**Re: Objection to MP08_0244 MOD 1 Modification Request for Mixed Used Development at 23-37
Lindfield Avenue and 11 Havilah Lane, Lindfield**

As a resident of Lindfield, I/we wish to lodge an objection against the proposed Modification of the subject development based on the following grounds:

Drawing Title
BASEMENT 3 PLAN

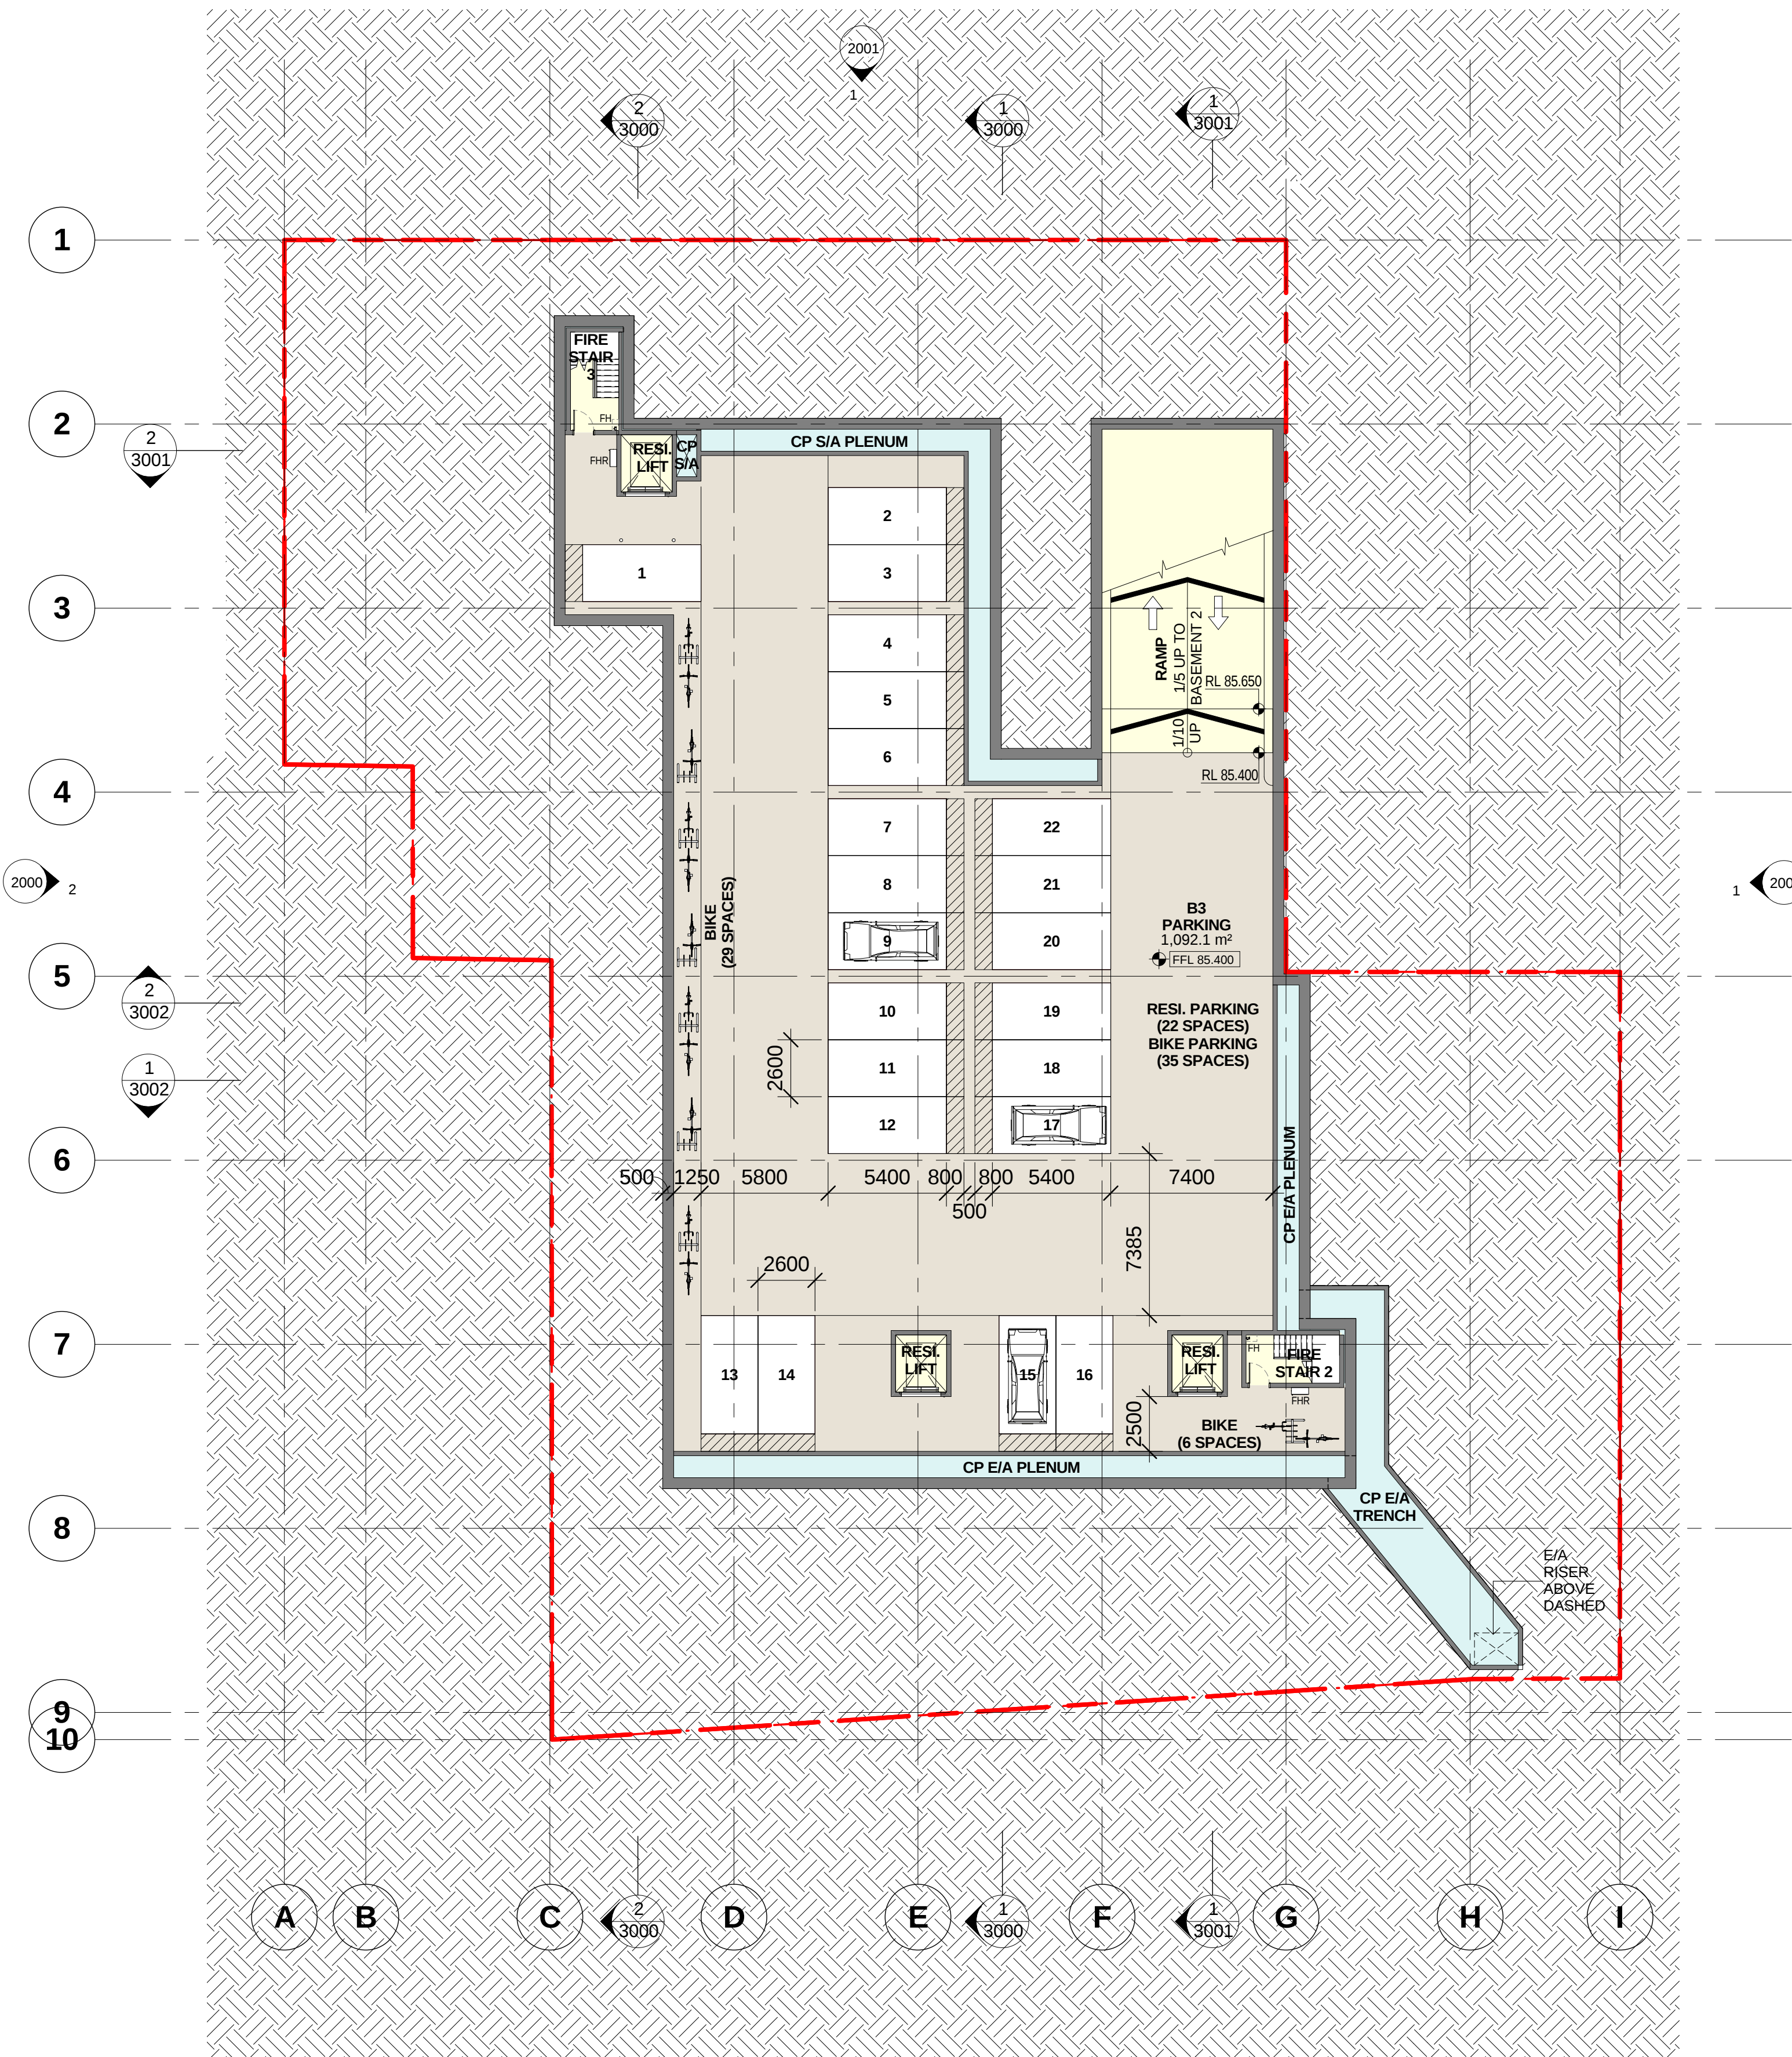
- Car spaces were identified as inadequate for the retail component and this has not been addressed relative to the remaining retail space proposed. The 25 car spaces counted as part of council's car park are also now highly uncertain due to the proposed rezoning and potential redevelopment.

1 HAVILAH LA ELEVATION
2001 SCALE1 : 250

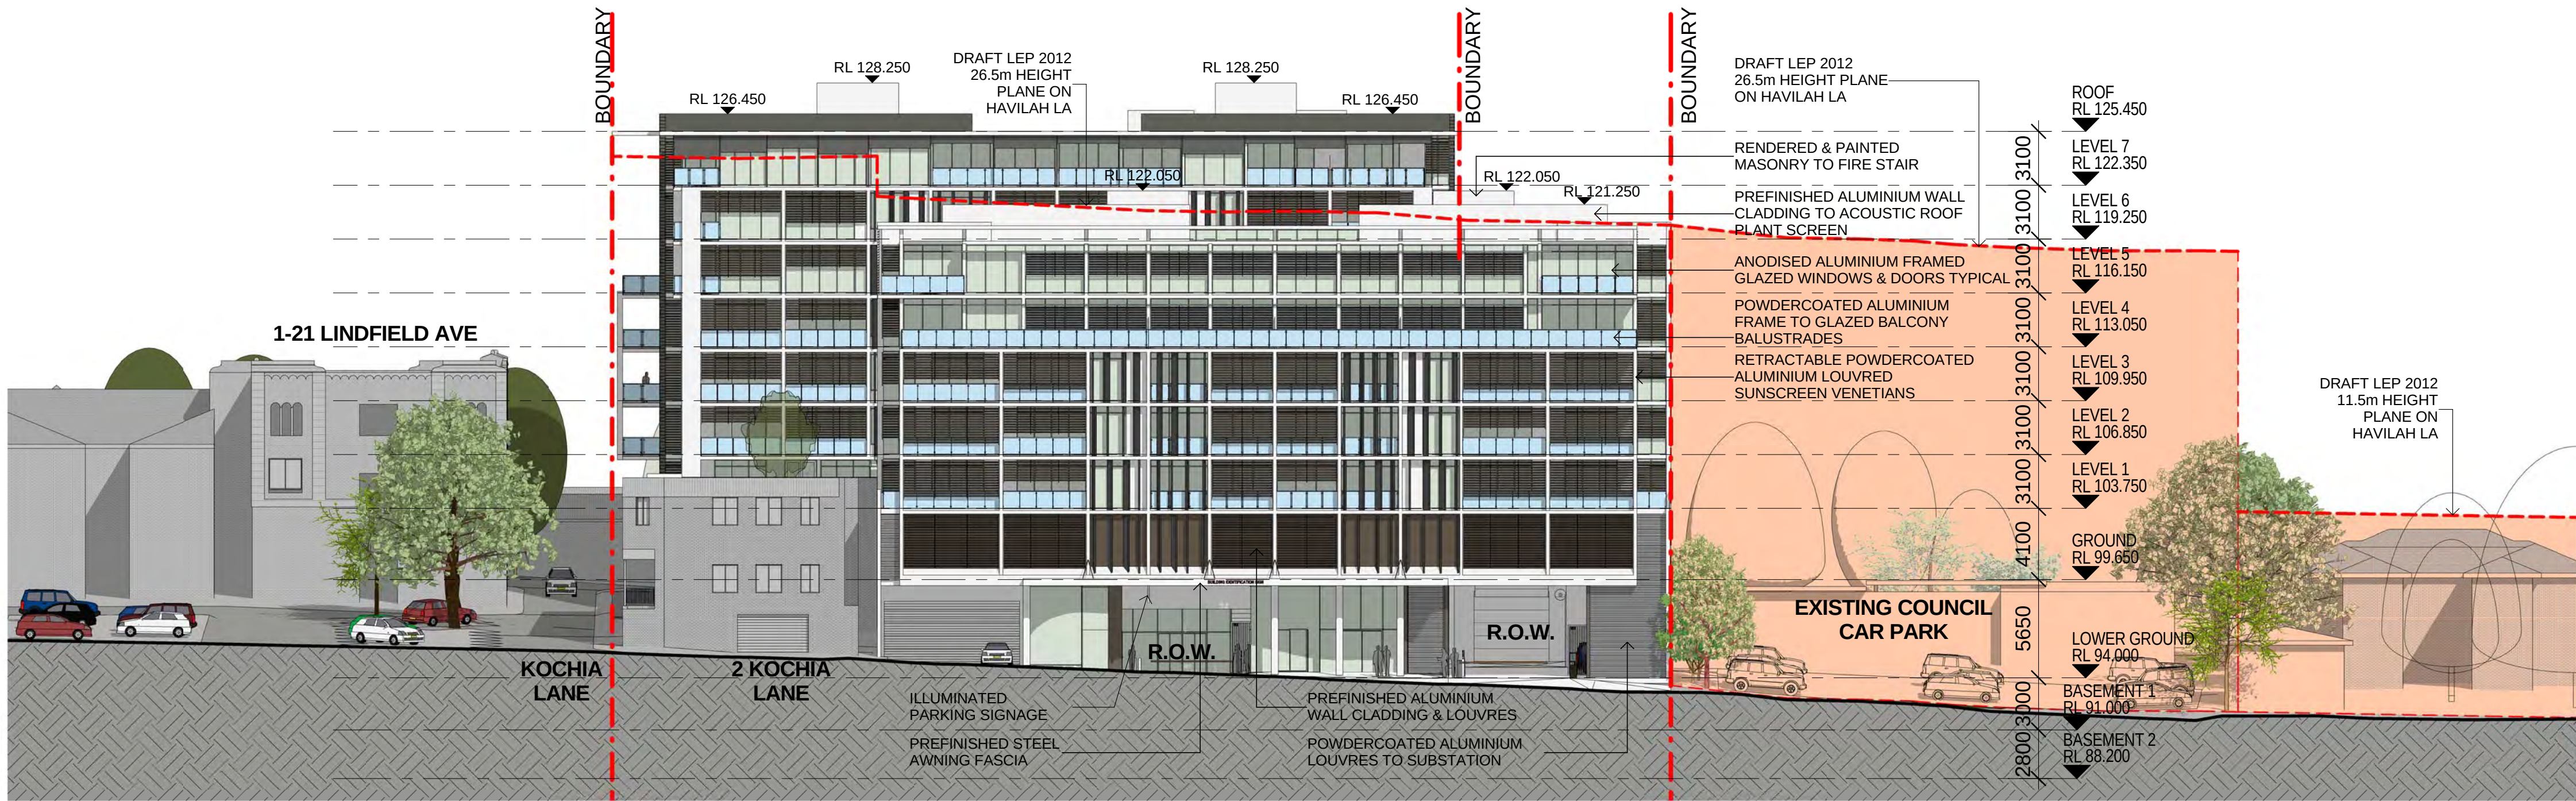
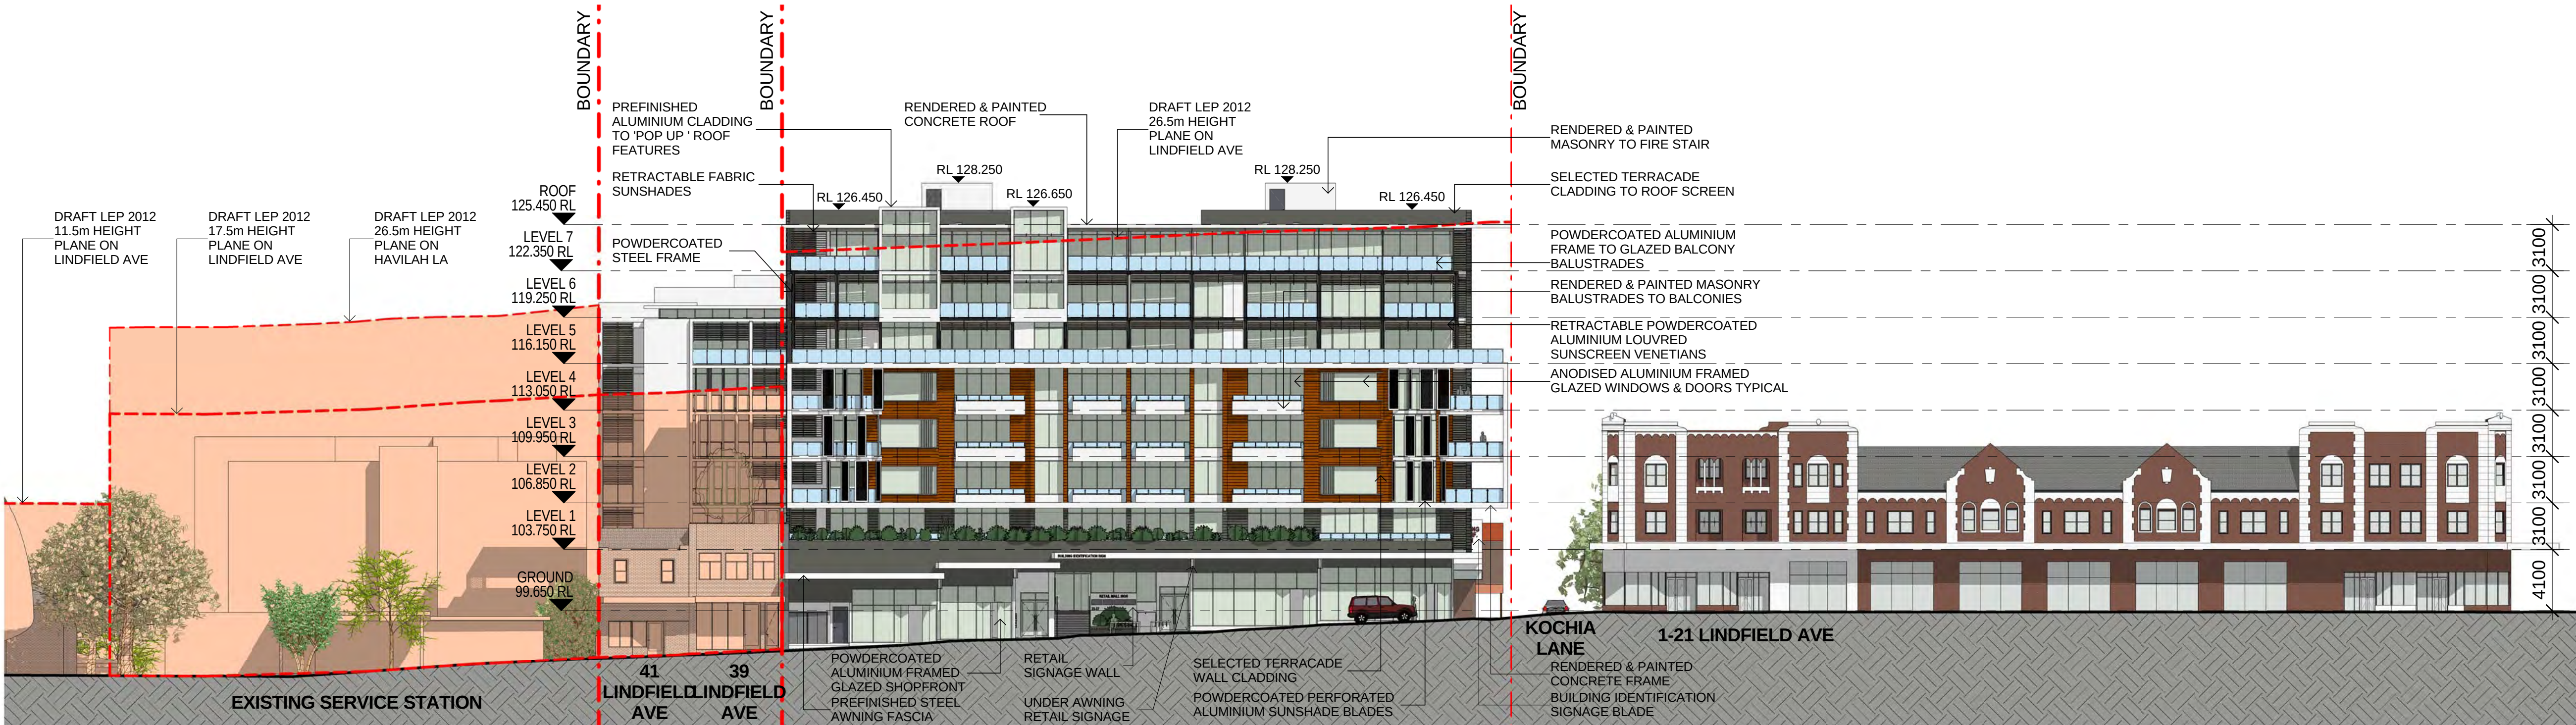
- The increase of an additional storey to both buildings: 8 storeys on Lindfield Avenue and 7 storeys on Havilah Lane creates excessive height and bulk and is out of character with the surrounding buildings, including the heritage listed adjacent building on Lindfield Avenue

- The additional storey (combined with less set back than the approved design) on Havilah Lane now creates privacy concerns for over 40 apartments in the adjacent 8 Havilah Lane, 8 Kochia Lane and 2-8 Milray Street residences
